From: Anita Gardner <Anita.Gardner@arun.gov.uk>
Sent: 30 June 2020 11:47
To: Planning.Responses <Planning.Responses@arun.gov.uk>
Subject: FW: FW: A/62/20/DOC - Pound Place, Roundstone Lane

I have the following comments regarding condition 3- surface water drainage:

TYPICAL SOAKAWAY DETAIL
"WAVIN AQUACELL"

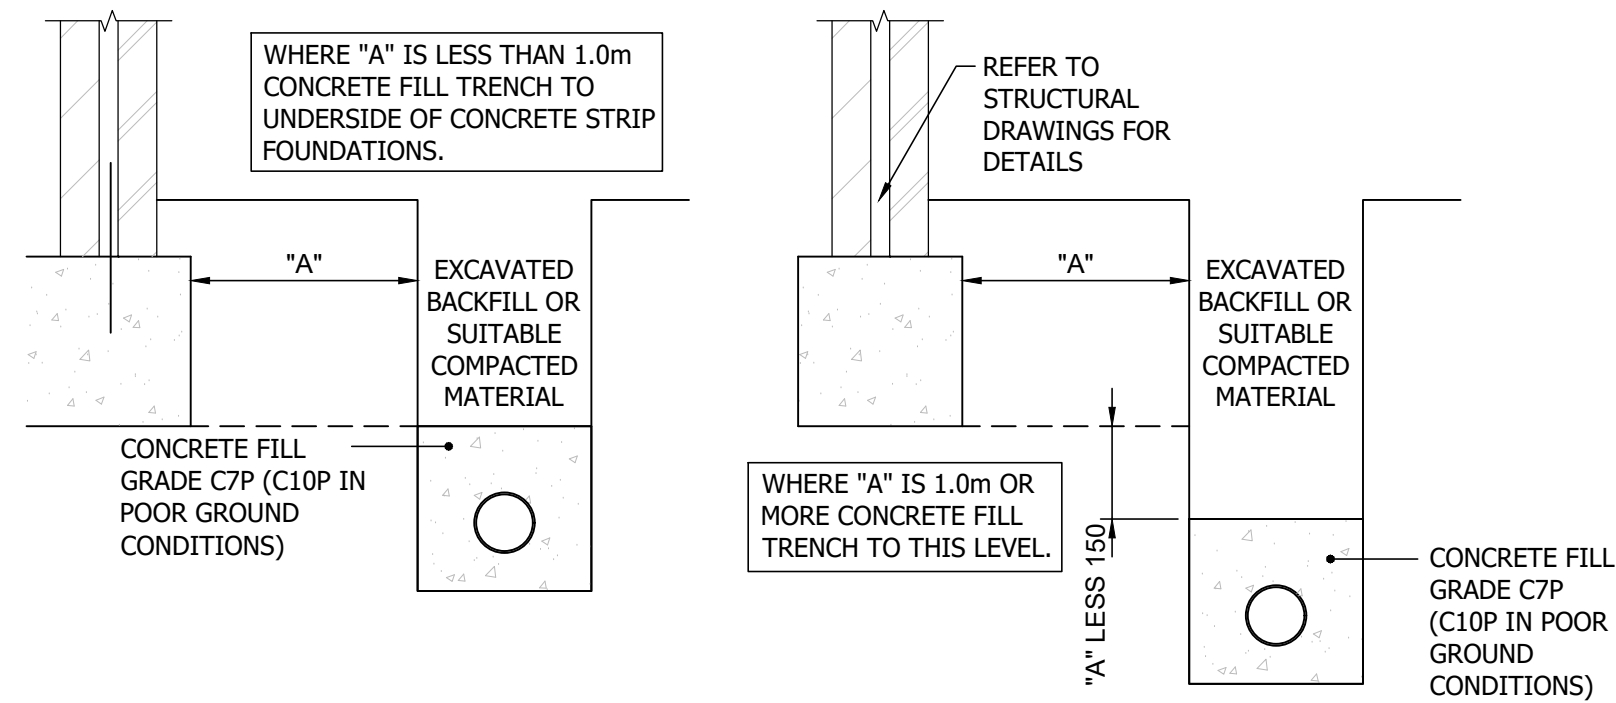
2. Please provide a revised catchment area plan.
3. Porosity of soakaways in calculations is set to 1, please correct to 0.95 as per standard for crates.

TYPICAL ROAD GULLY DETAIL

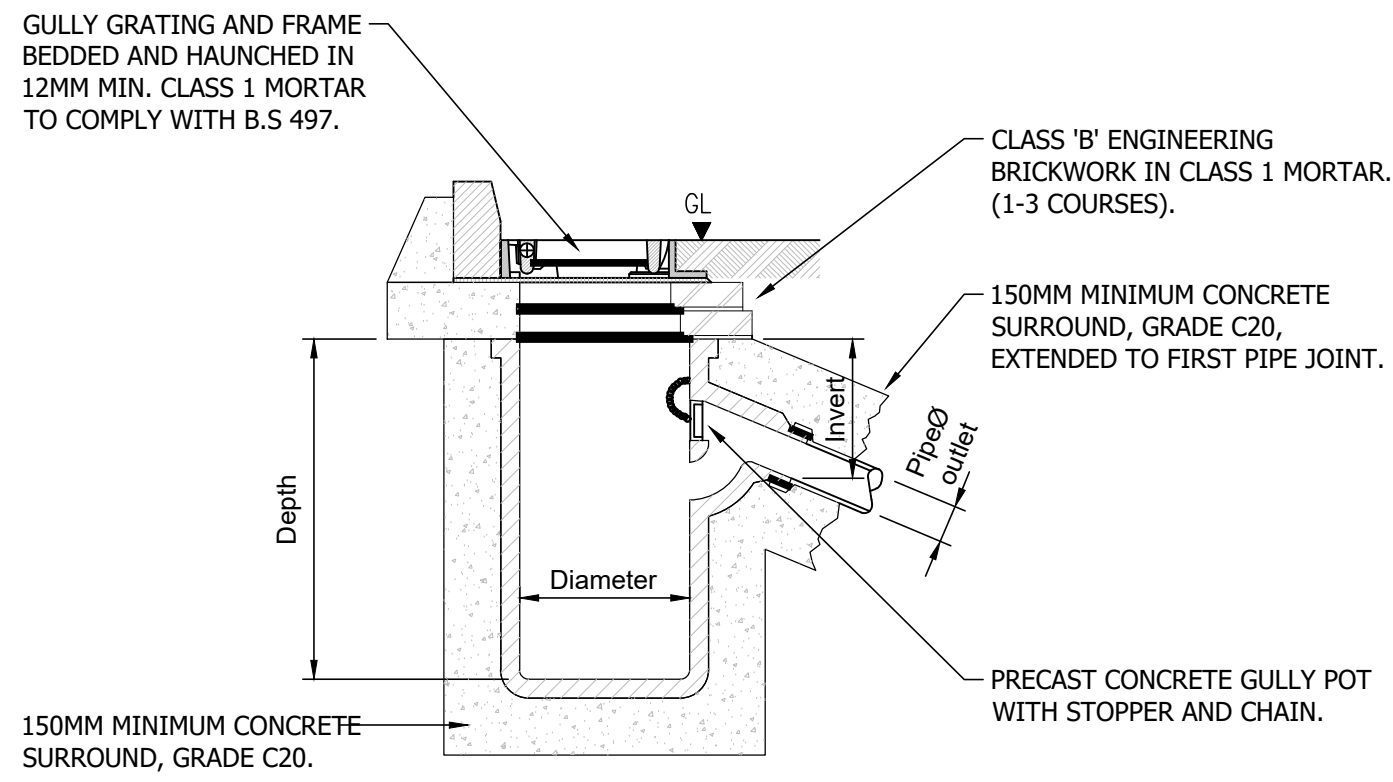
4. Please provide invert levels of diffuser blocks on plan. Please detail diameter of pipes connecting from these to network on plan.
5. Please detail cover level of gullies.
